CITY OF ALBUQUERQUE

July 22, 2021

**Re: McMahon Shopping Center
McMahon/Unser NW
Traffic Circulation Layout
Architect's Stamp 07-20-2021(A11-
D017B)**

UNSER & MCMAHON  
ENLARGED SITE PLAN  
ALBUQUERQUE, NM  
PROJECT #2063

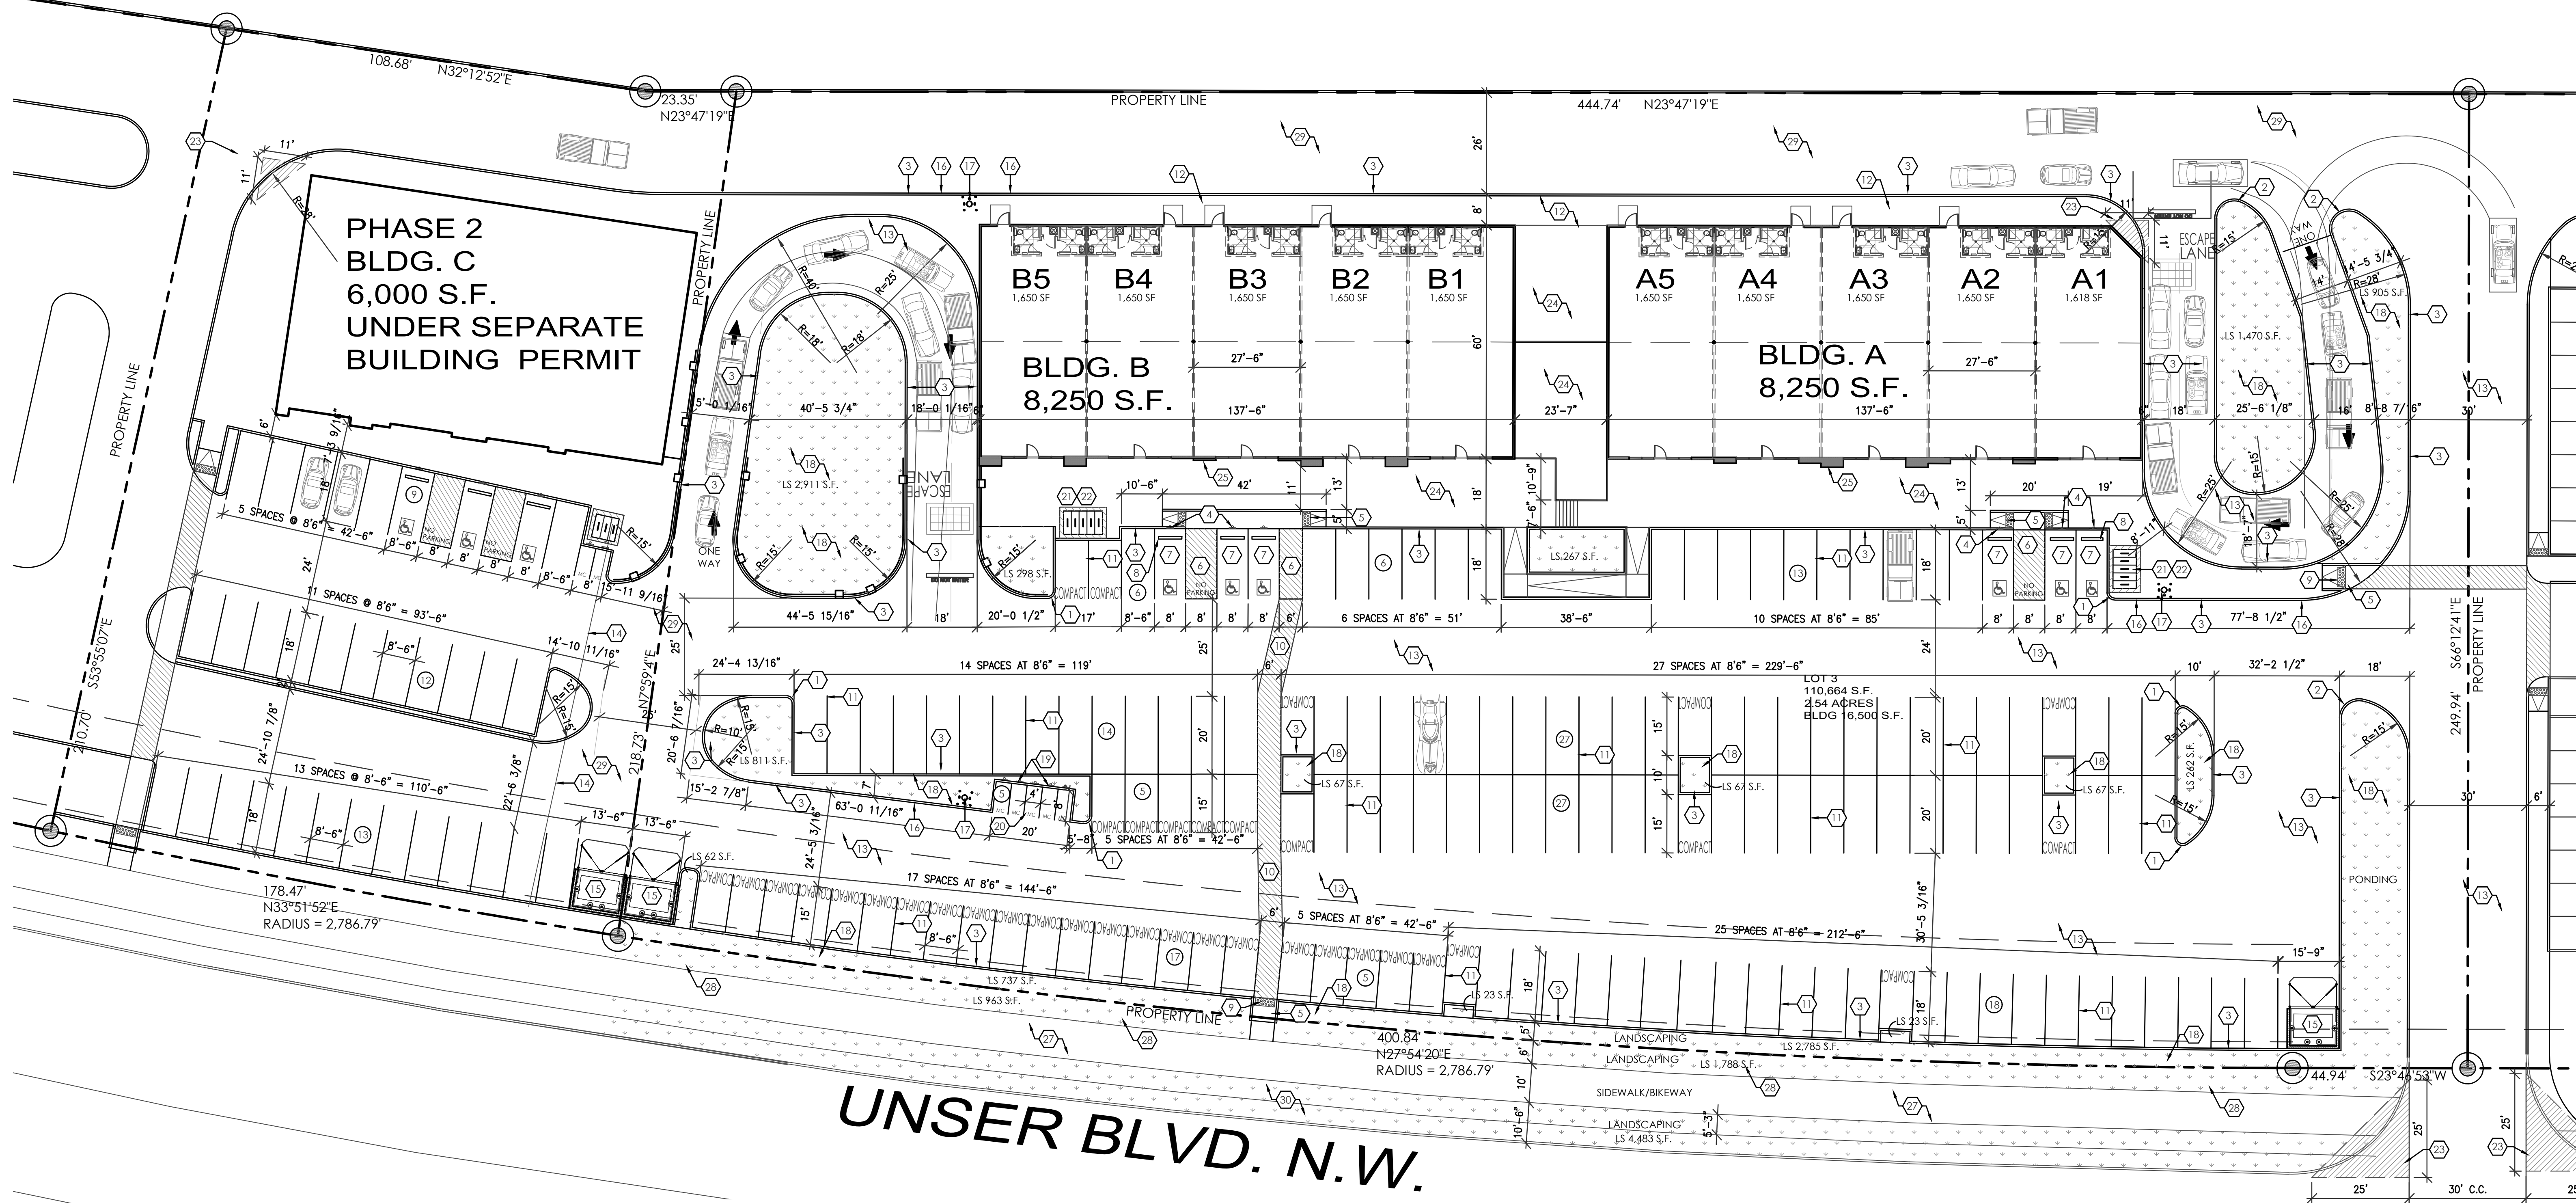
3. **Another access entrance/point is need to provide emergency accommodation for ingress/egress. This access can be provide off Bandelier, McMahon or any other access point deem necessary.**

4. How will you service the Main Circulation Road behind buildings A & B: **You show how a vehicle encroaches into the drive thru lanes which is a safety concern. Please address these concerns.**

8. Identify all existing access easements and rights of way width dimensions.
9. **Identify the right of way width, medians, curb cuts, and street widths on Unser Blvd NW.**

10. Please list the width and length for all proposed parking spaces. **Some dimensions are not shown.**

12. **ADA curb ramps must be updated to current standards and have truncated domes installed.**
13. Motorcycle parking spaces shall be designated by its own conspicuously posted upright sign, either free-standing or wall mounted per the zoning code. Label pavement MC.

18. **List radii for all curves shown; for passenger vehicles. Radius for delivery trucks, fire trucks, etc. is 25 ft. or larger.**
19. **Per the IDO, a 6 ft. wide ADA accessible pedestrian pathway is required from the public sidewalk to the building entrances. Please clearly show this pathway and provide details.**

20. **Per DPM, a 6 ft. wide ADA accessible pedestrian pathway is required from the ADA parking stall access aisles to the building entrances. Please clearly show this pathway and provide details.**

21. **ADA 6ft wide Pedestrian continuity needs to be provided between buildings A & B**
22. The proposed ADA parking stall:
- Ramp are only 5 ft width. 6ft is the requirement.**

- The back of ramps are a safety concern (tripping hazard) for pedestrians.**

23. **Unser pathway: Provide widths of existing pathway.**
24. All one-way drives shall have "One Way" and "Do Not Enter" signage and pavement markings. Please show detail and location of posted signs and striping.

25. **The minimum drive through lane width is 12 feet with a 25 foot minimum radius (inside edge) for all turns. (A 15 foot radius can be used with an increase in lane width to 14 feet). Please dimension all lane widths and radii.**
